Planning Application AL/70/20/PL – Proposed Residential mews (Six New Build Terraced Houses), West Barn, Norton Lane, Norton.

On behalf of my client, Mr S McHale, I wish to express my concerns regarding the above application.

Proposed Site Plan

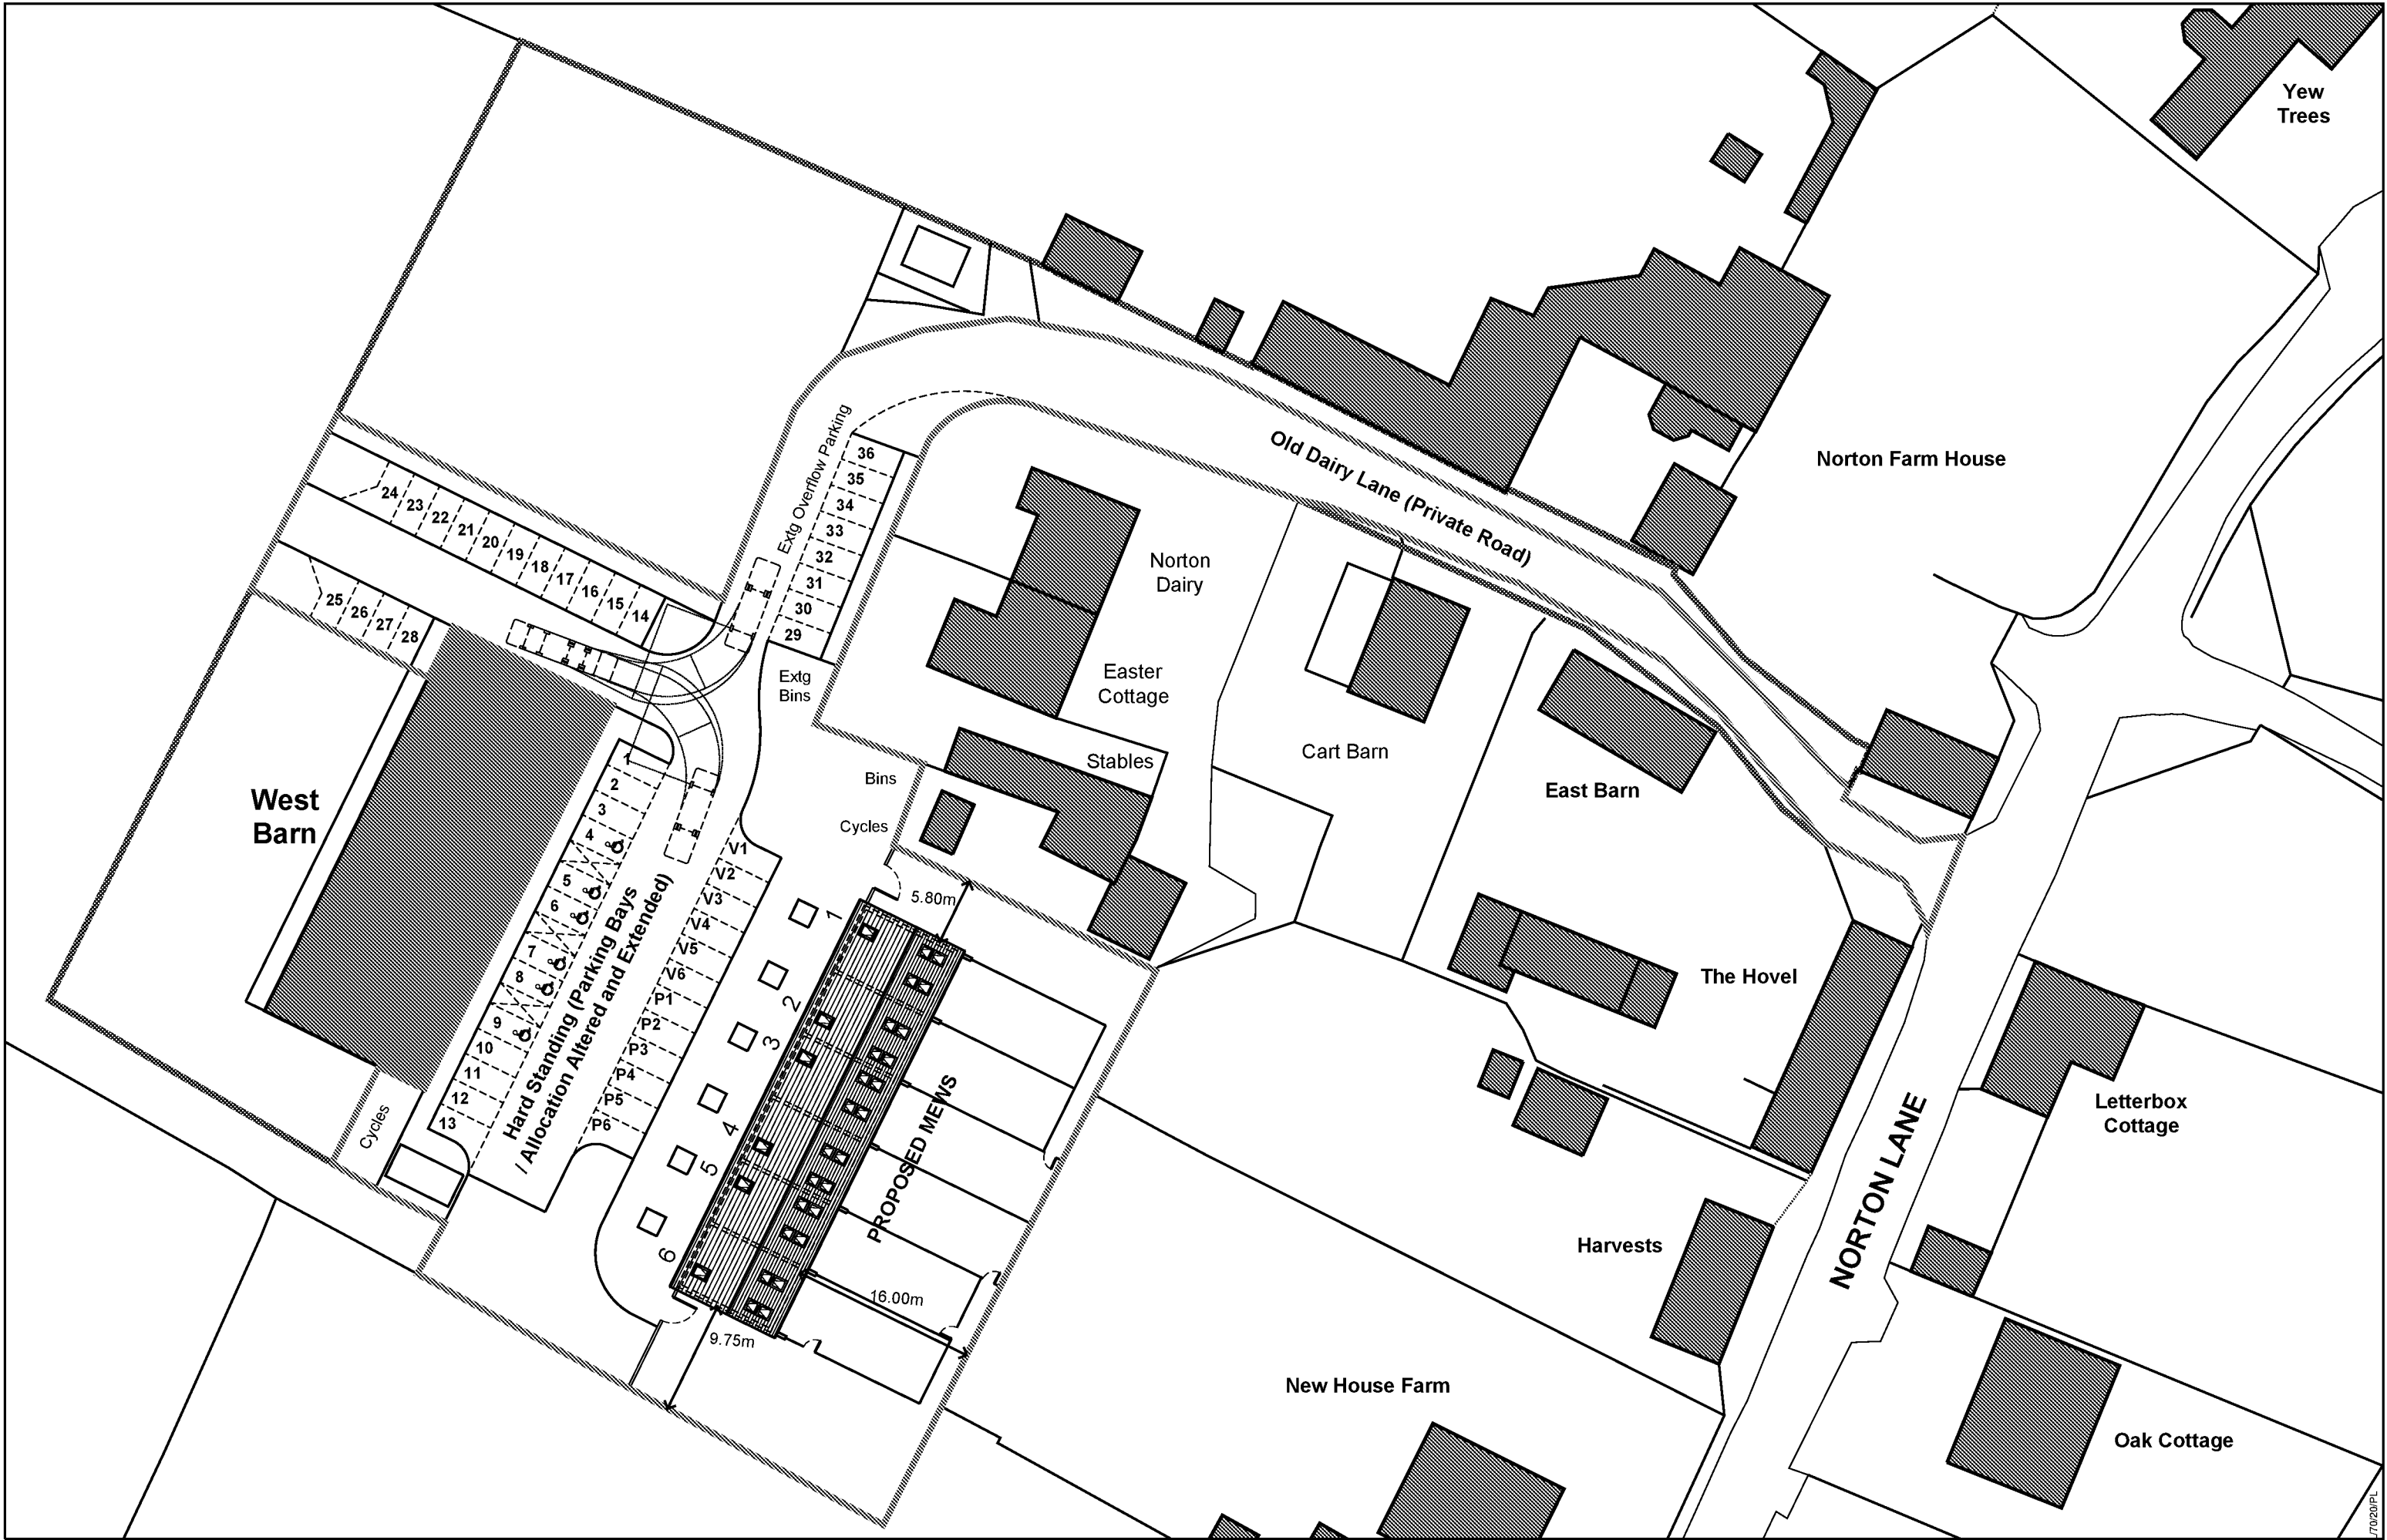
The block plan shows the dwellings as having individual gardens. Conversely all of the perspective drawings show a single communal rear garden. Visually and in terms of living conditions the two would be very different. Could the applicant please clarify what they propose.
